Department of Planning and Environment
Major Projects Assessment
PO Box 39
Sydney NSW 2001

Submission of Objection

Integra Mine Complex Modification 4- Biodiversity Offset Strategy
08_0101 MOD 4 and 08_0102 MOD 4

Figure 9: Biodiversity Offset Areas (BOAs)

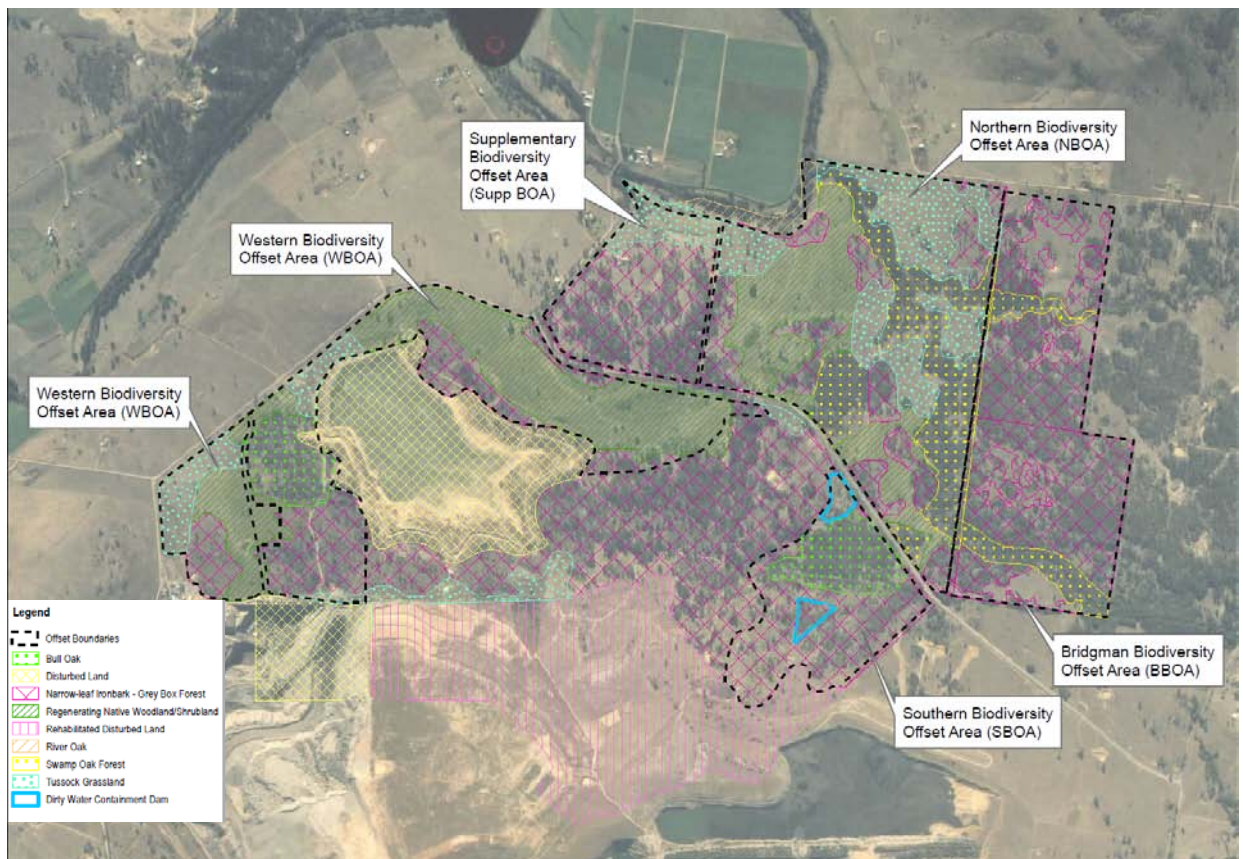
1. The proposal to remove the supplementary and a significant section of the northern onsite offset areas will impact on the protection of a large meander in Glennies Creek.

2. The loss of the western onsite area and a significant section of the Martins Creek offset area reduces the connectivity design of the current approved Biodiversity Offset Strategy.

3. The proposed new offsets, 30kms away from the impacts of the mine, do not contain either of the endangered ecological communities (EEC) approved to be destroyed. These are Central Hunter Ironbark-Spotted Gum-Grey Box Forest EEC and Swamp Oak Floodplain Forest EEC.
